# Site Plan Letter of Intent

2290 Old Ranch Rd., Colorado Springs, CO 80908

**Review 1 Comment:** Please identify the average daily trips that your development is expected to generate. Address the criteria for not providing a traffic impact study listed in Appendix B.1.2.D of the Engineering Criteria Manual. I have attached an excerpt from the ITE trip generation manual of the General Office for your use.

SHEET NUMBER: L

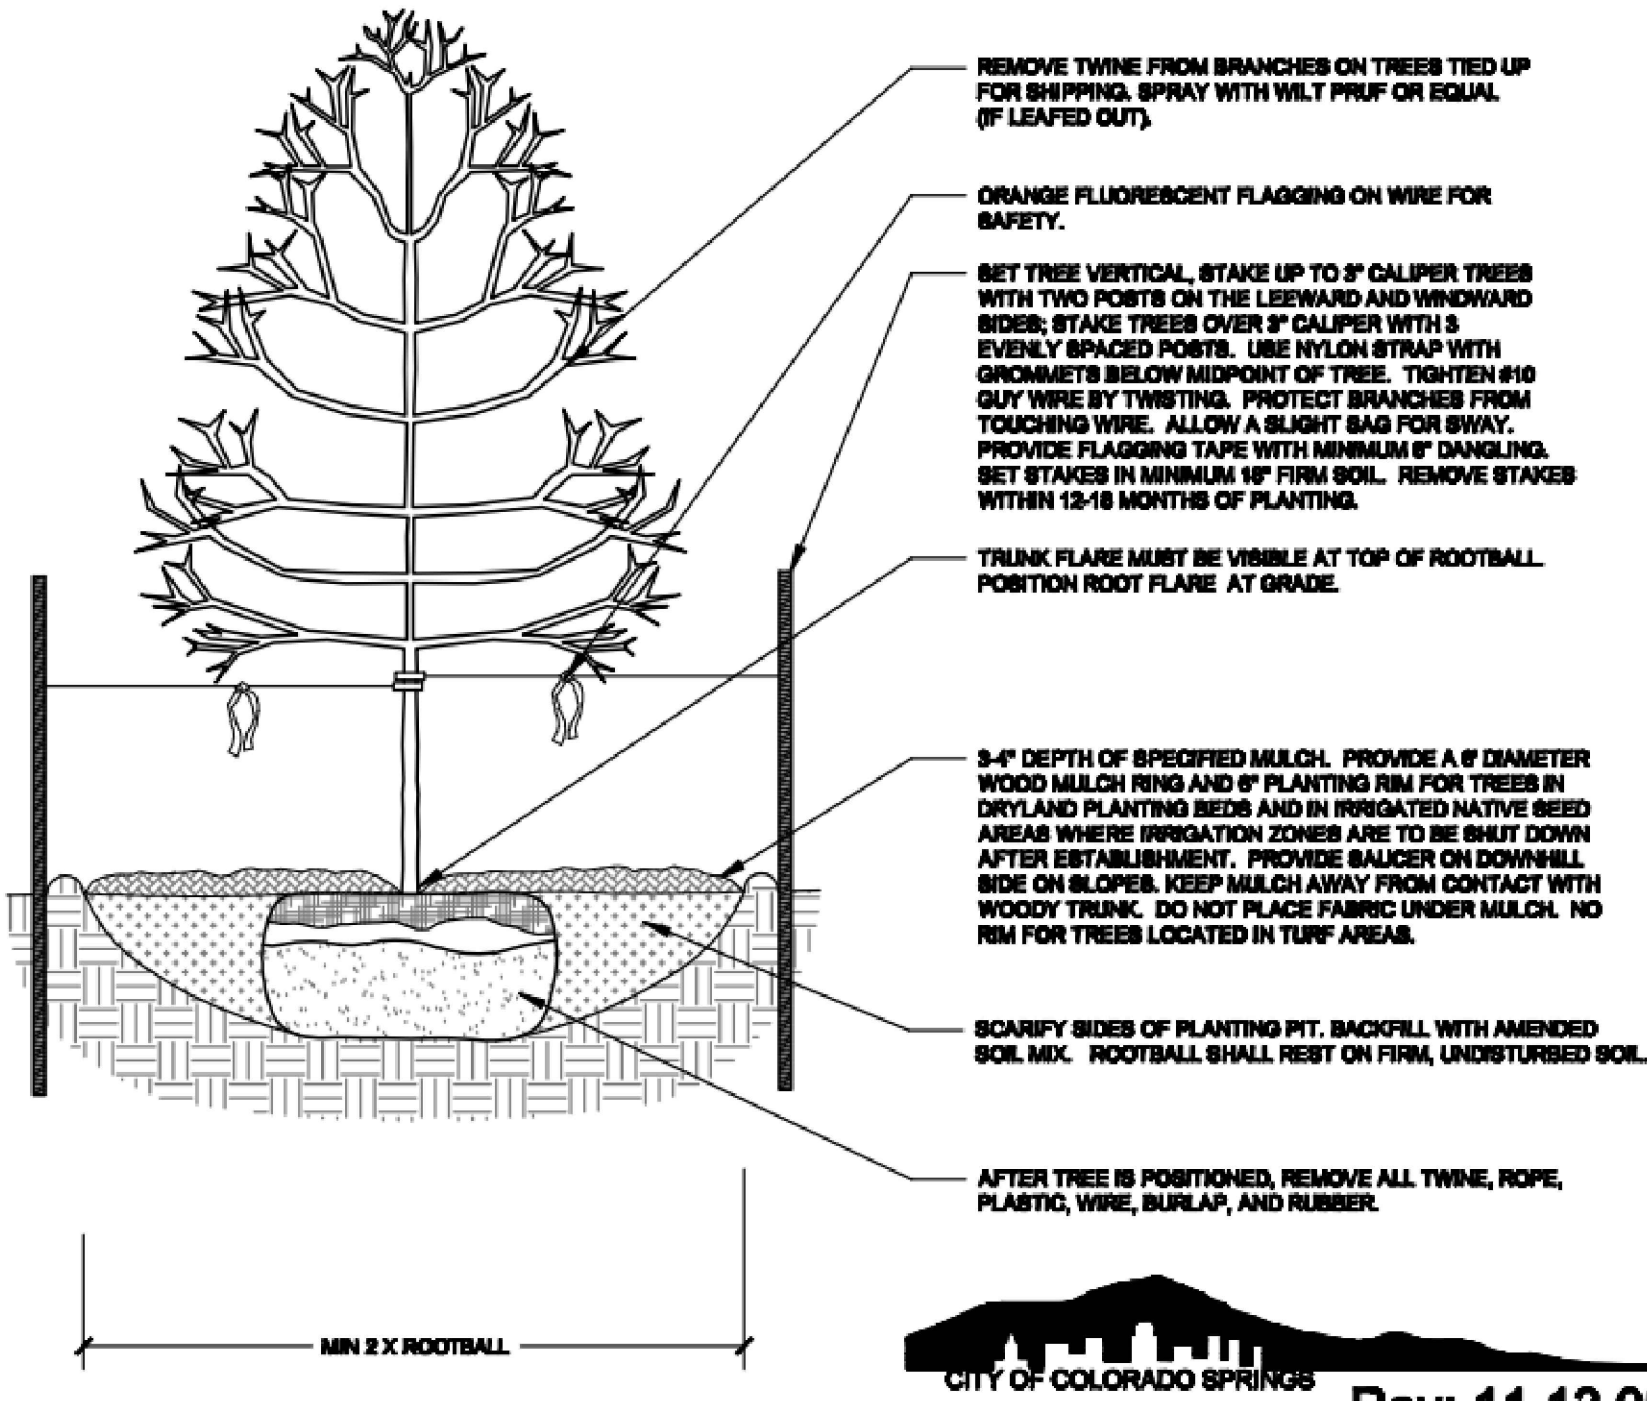
In order to justify alternative landscaping, it must be specified how the proposed alternative meets the standards of LDC Sec. 6.2.2(A)(4), indicating how the proposed landscaping meets the purpose of the LDC Section 6.2.2, promotes the concepts contained in the Landscape and Water Conservation Manual, and provides an equivalent benefit to the community and environment as would otherwise be achieved by meeting the requirement.

If you cannot provide adequate justification for the alternative landscaping, you will be required to meet the requirements of Sec. 6.2.2.
